**City of Portland, Maine - Building or Use Permit**

Permit No: 04-1692	Date Applied For: 11/12/2004	CBL: 082 B008001
--------------------	------------------------------	------------------

Location of Construction: 105 Noyes St Dowd Properties Llc Owner Name:	Owner Address: 17 Westland Ave Owner Name:	Business Name: Dowd Properties Llc Contractor Name:	Contractor Name: Dowd Properties Llc Contractor Name:	Lessee/Buyer's Name: Dowd Properties Llc Contractor Name:	Phone: Dowd Properties Llc Contractor Name:
Proposed Use: single family home with replacement front porch, deck, roof		Proposed Project Description: Repair front porch deck and roof of single family home

Porch Roof Perimeter Frame.

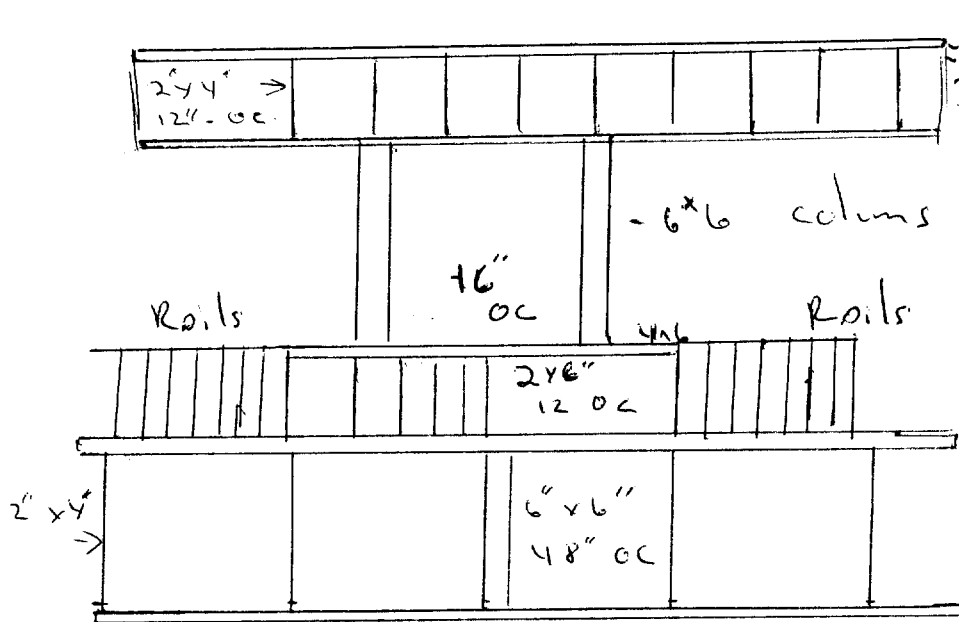
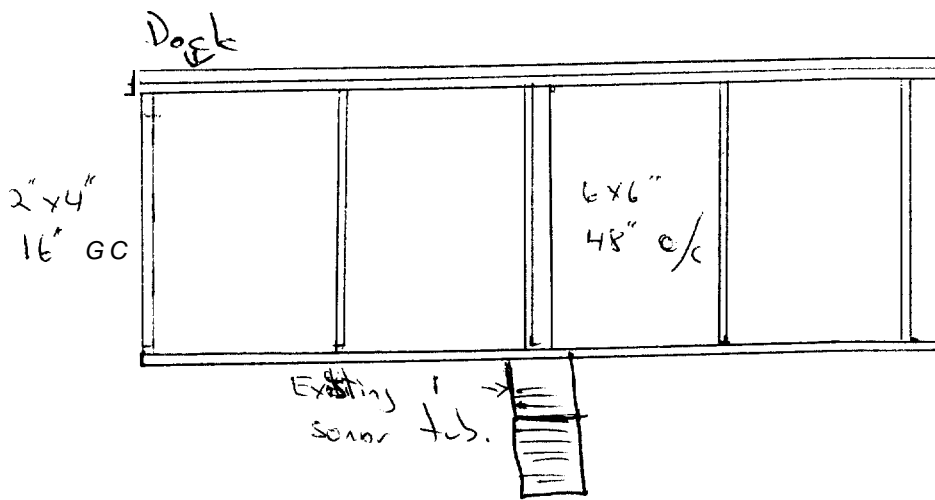
- 1) As discussed, any rafters that need tp be sister/replaced must be 2"x 8"-s 16" oc or 2"x 6"-s 12" oc.
- 2) Permit approved based on the plans submitted and reviewed w/owner/contractor, with additional information as agreed on and as noted on plans.
- 3) Separate permits are required for any electrical, plumbing, or heating.
